CITY OF ALBUQUERQUE

RE: Townhomes for Greg Lobbereg
Grading and Drainage Plan
Engineer's Stamp Date 2-6-2017 (File: H22D026)

RE: 2400 Marie Park Townhomes (H22 / D1026)

Thank you for your review comments of January 20, which have been addressed as follows:

CIVIL103

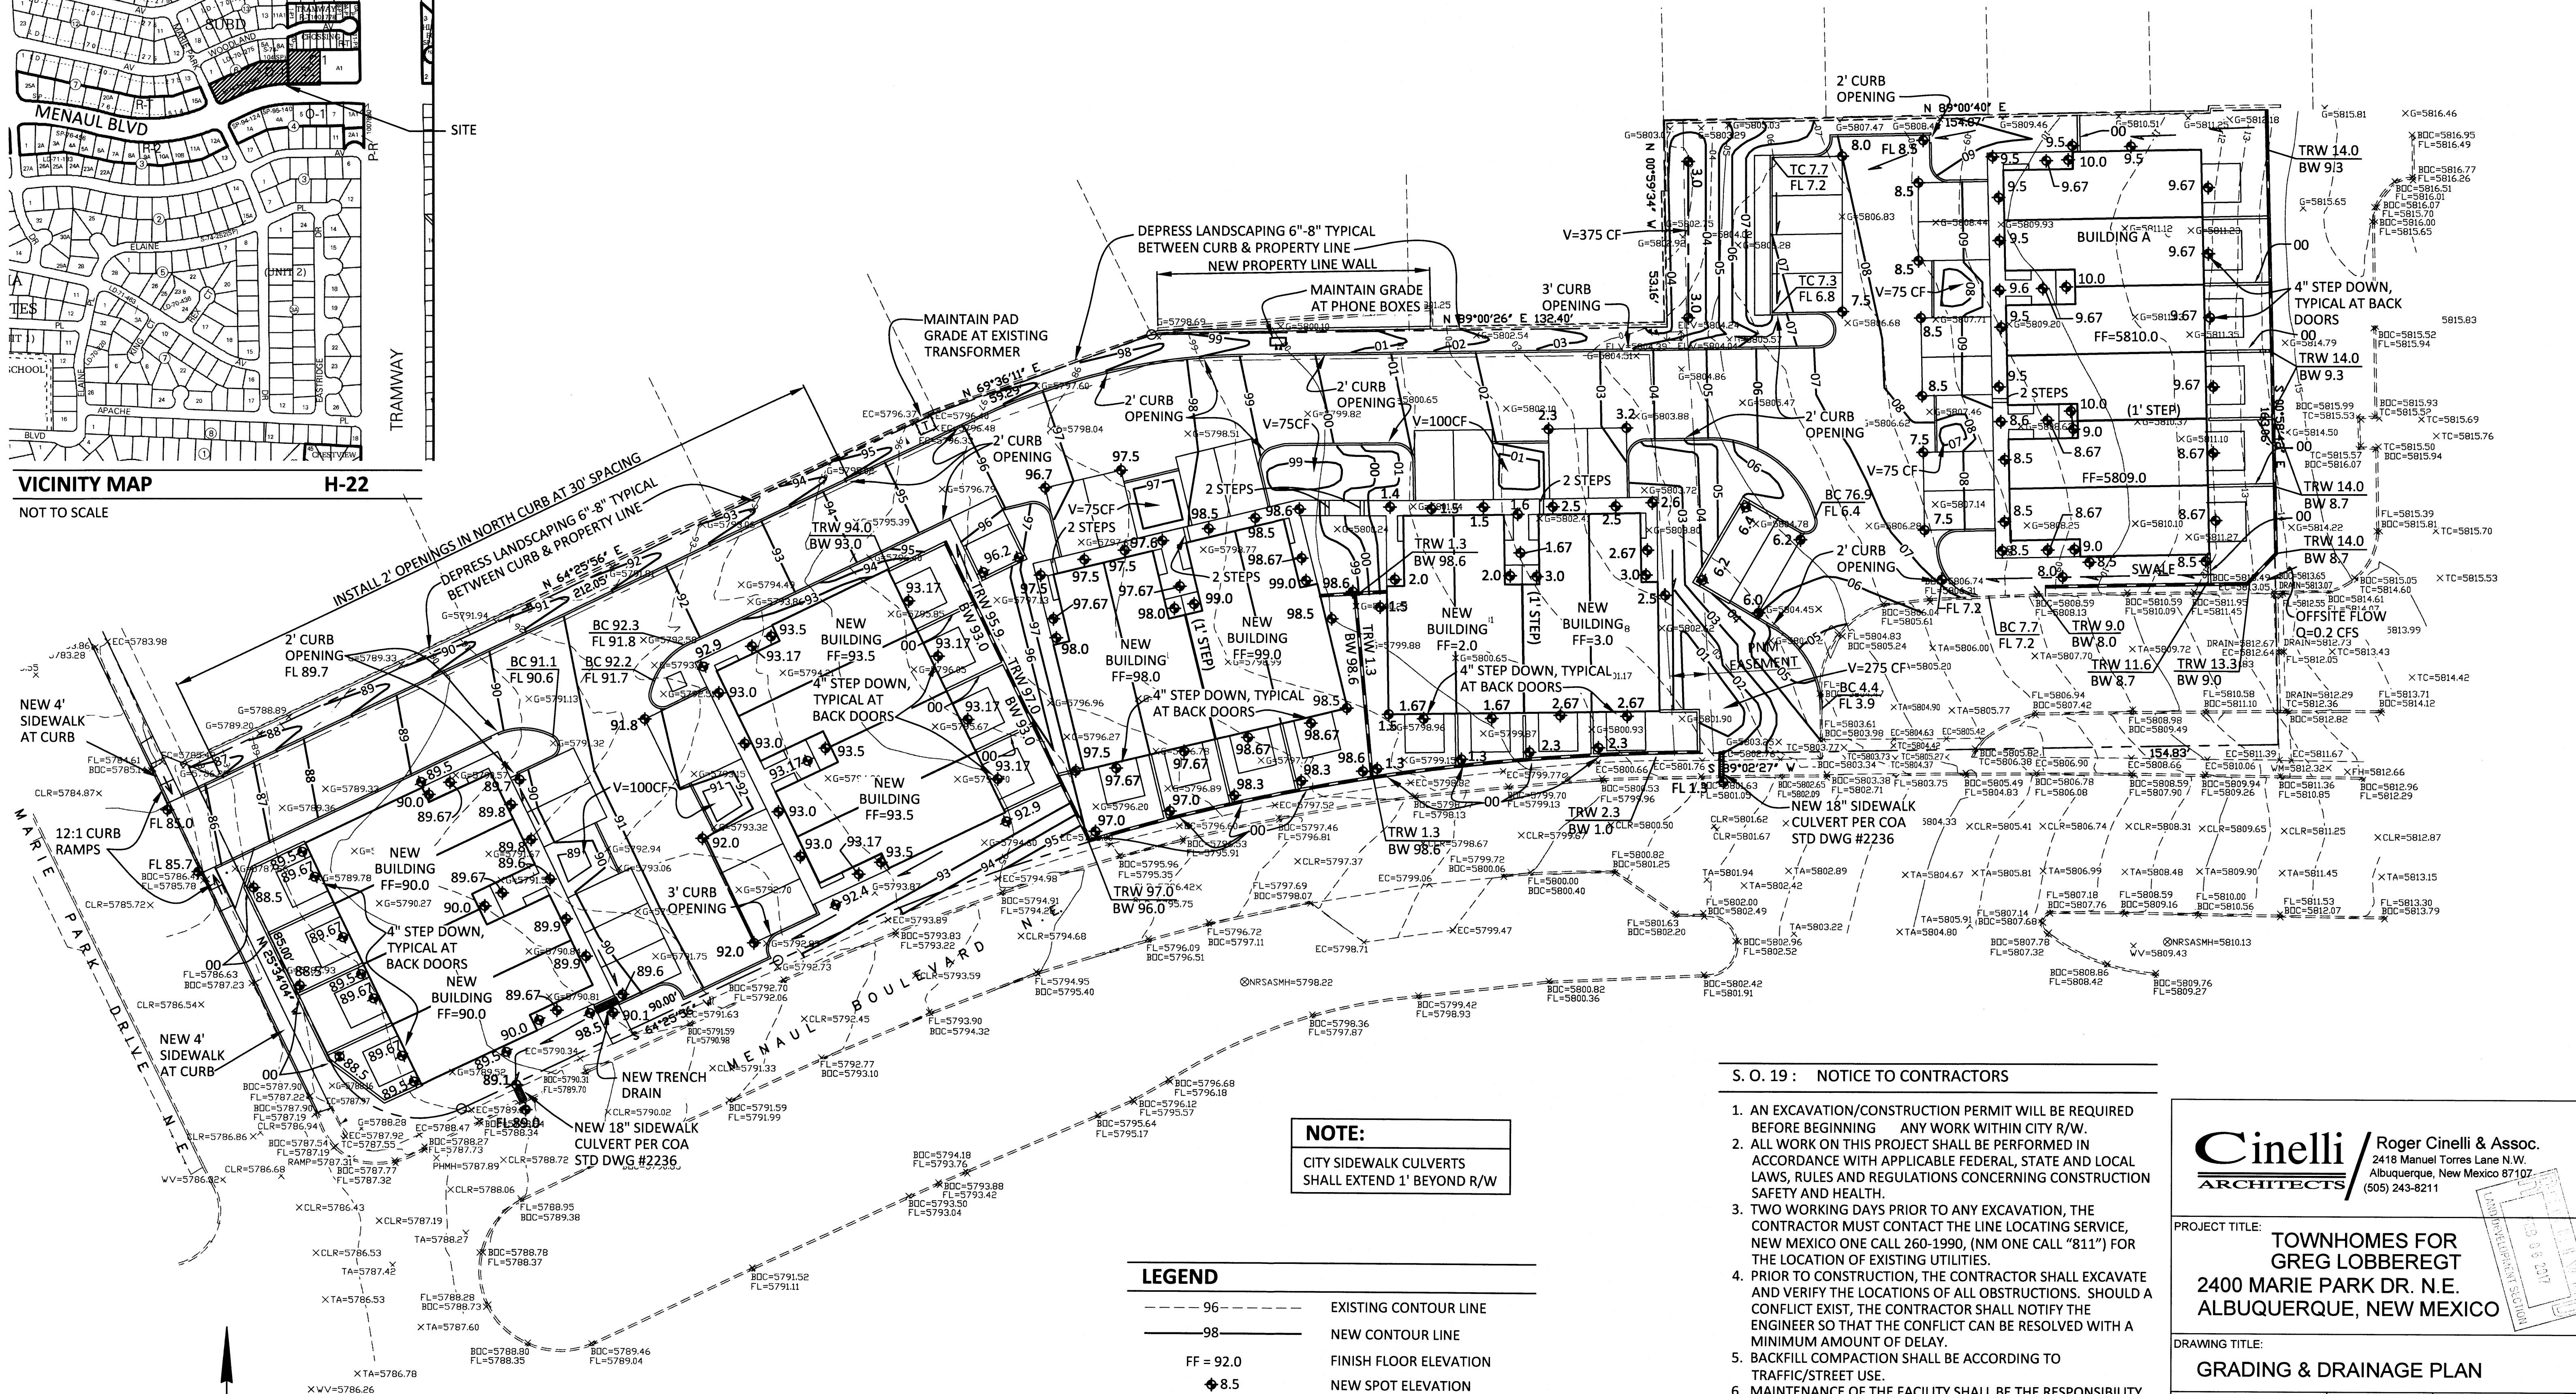
- 1-2. Vicinity Map and Offsite flow narrative have been added.
3. Typical unit and backyard detail has been included.
4. The 1st flush volume calculations have been revised.
- 5-6. Additional curb cuts have been noted on the plan.
7. Landscape strip north of access drive has been noted and shown as depressed.
8. The ESC plan is being prepared by others.
9. Backyards of units that back up to public streets are now shown draining to the street.
10. A note has been added requiring sidewalk culverts to be extended 1' beyond R/W line.
